PLANNING AMENDMENT

Application No. H21/0142/96
Date Registered 25 MAR 1996
Case Officer OG

REF: ERECTION OF 5 BUNGALOWS TO INCLUDE SITING AND LANDSCAPING,
CHURCHWAY, TYDD ST MARY. FOR. S P AND J SANDERSON.
PLANNING REF: H21/0142/96.

Amendment Submitted: Reduce width of bungalows and detached garages (Plots 2, 3, 4 & 6 (front elevations of plots 2, 3 & 4)). Additional landscaping (reposition access) - Drawing no. SH/230/96).

SITE PLAN 1-200.

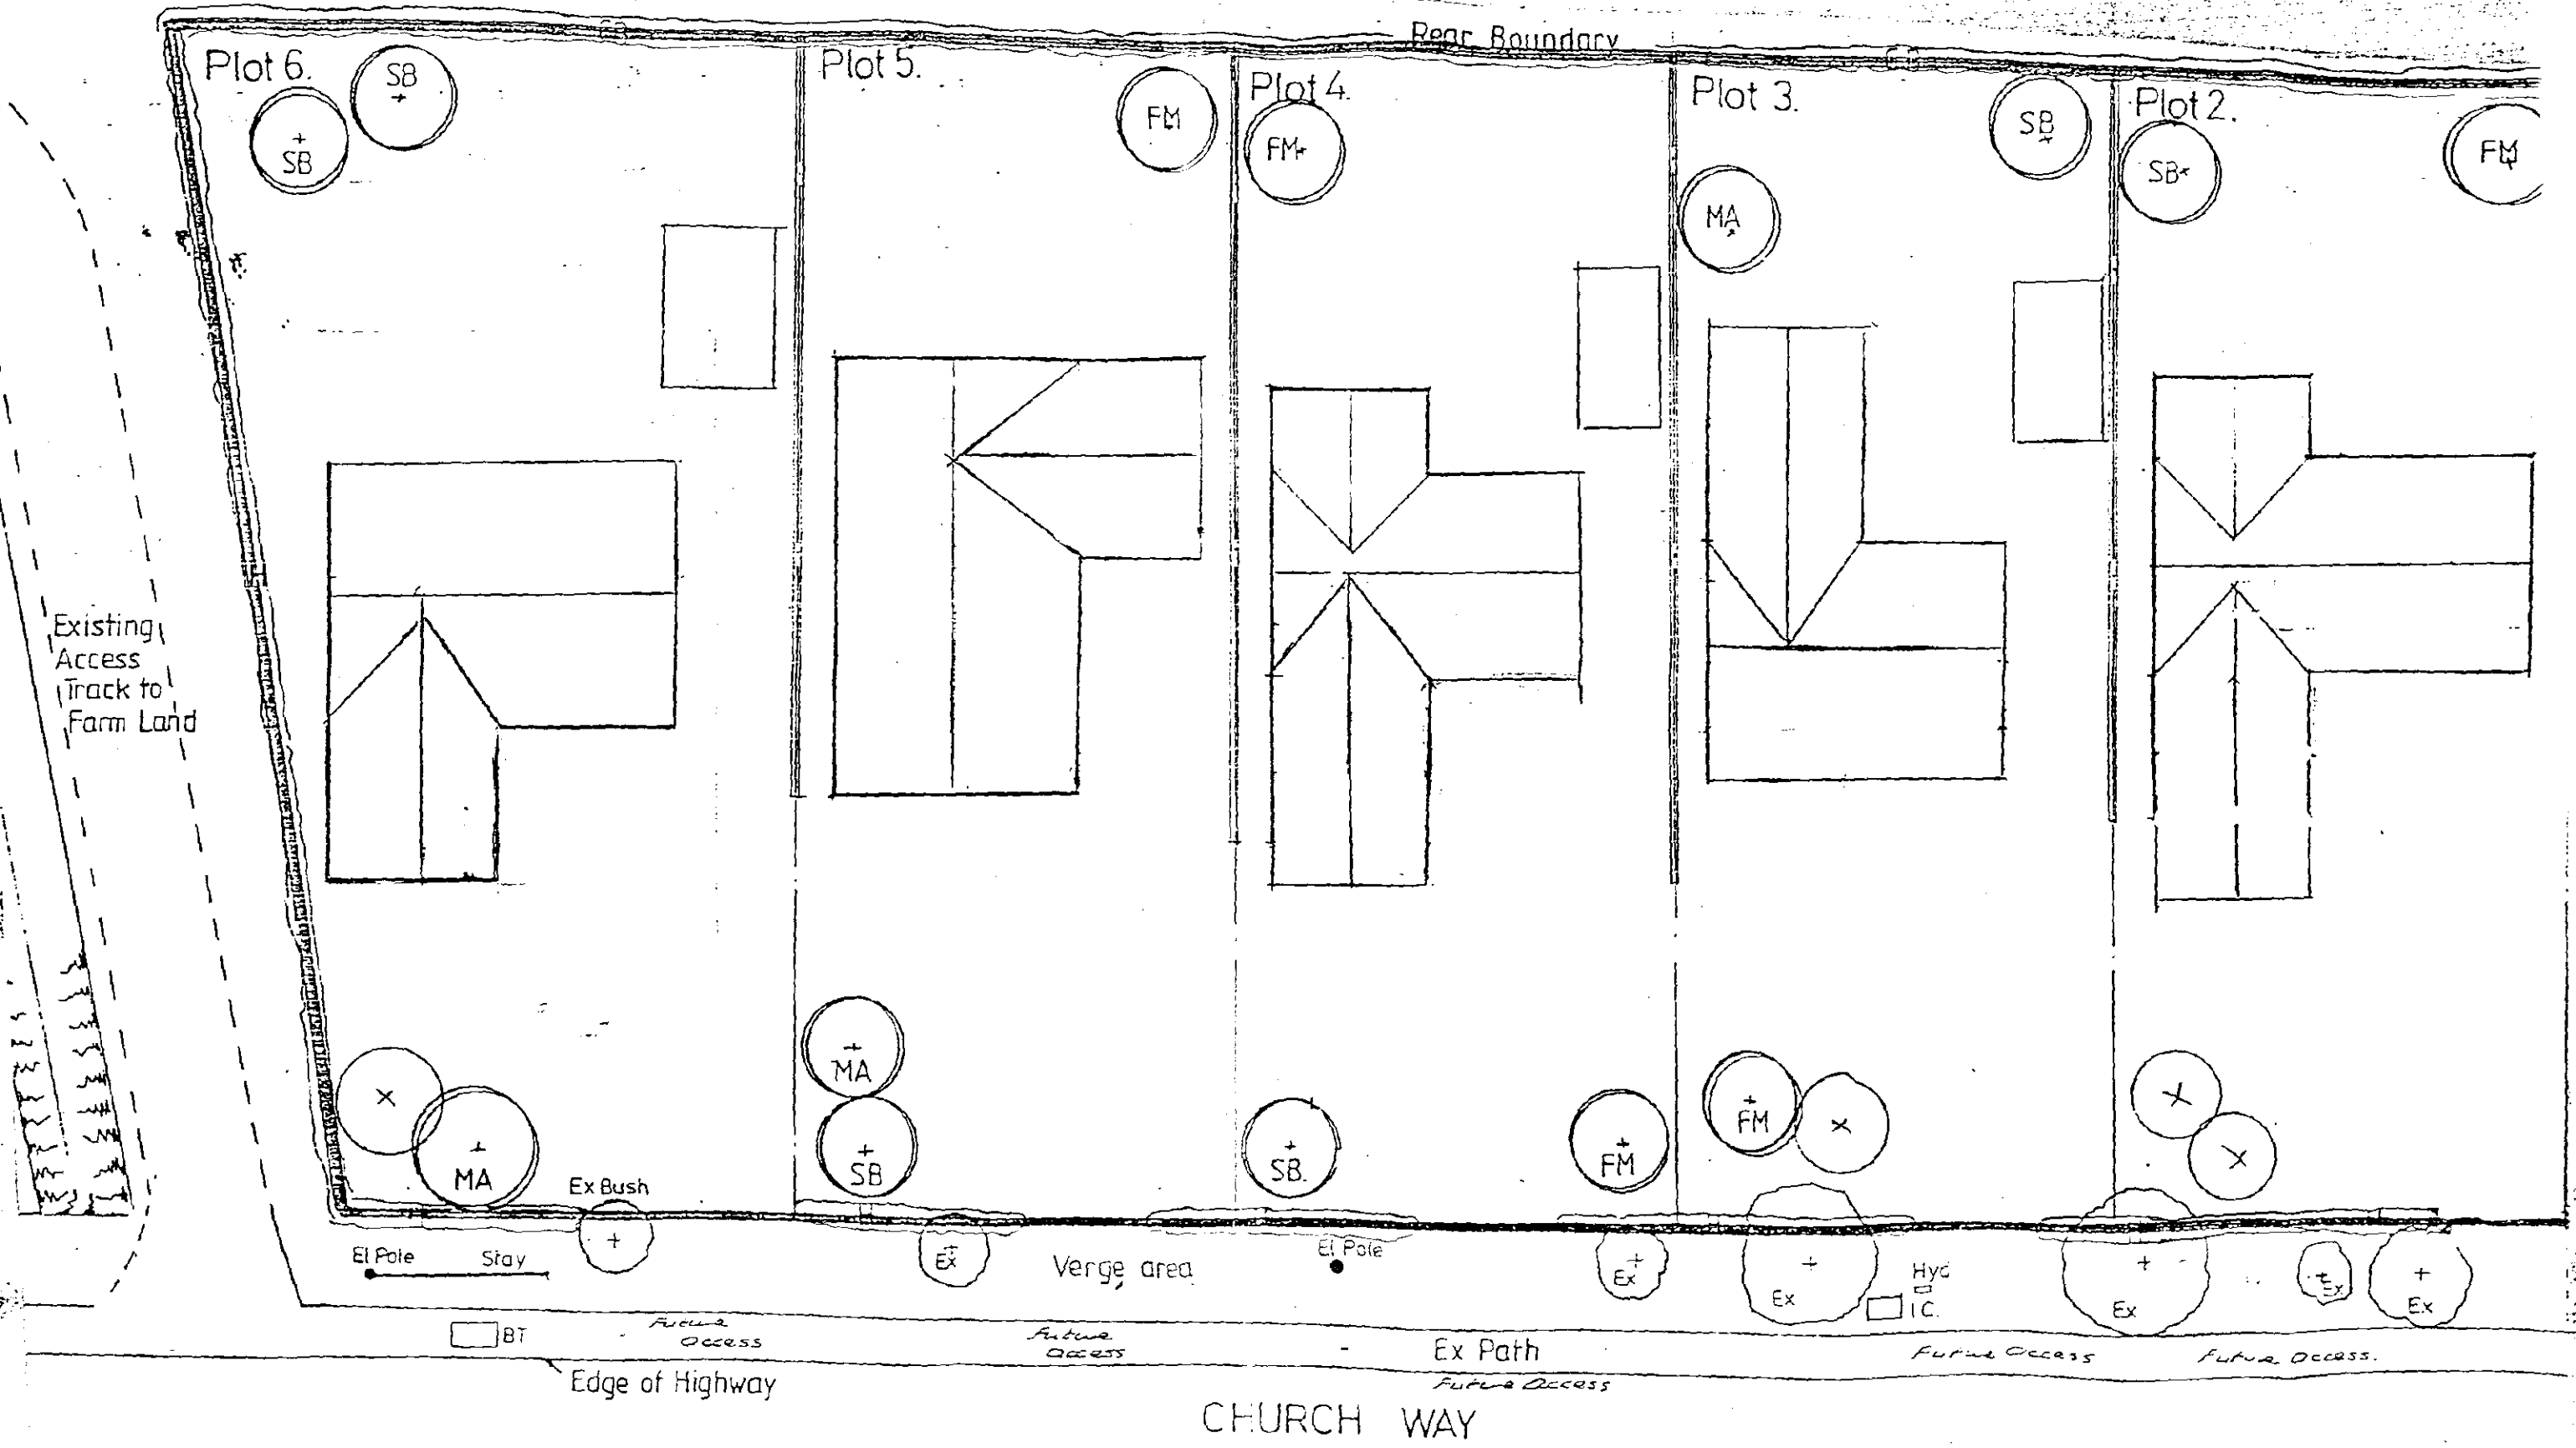
REDUCED WIDTHS OF BUNGALOWS
+ DETACHED GARAGES
PLOTS 2, 3, 4 & 6. (FRONT GLEDS
PLOTS 2, 3, 4)
ADDITIONAL LANDSCAPING.
(REPOSITION ACCESS).
SEE ALSO LETTER
DATED 21/3/96

The Bungalows on Plots 2,3,4, are to be reduced in width and the garages are to be detached. This will give a more open scheme as requested. Plot 6 will be amended as your sketch etc.

Finally additional front planting will be incorporated as shown on the revised site plans enclosed.
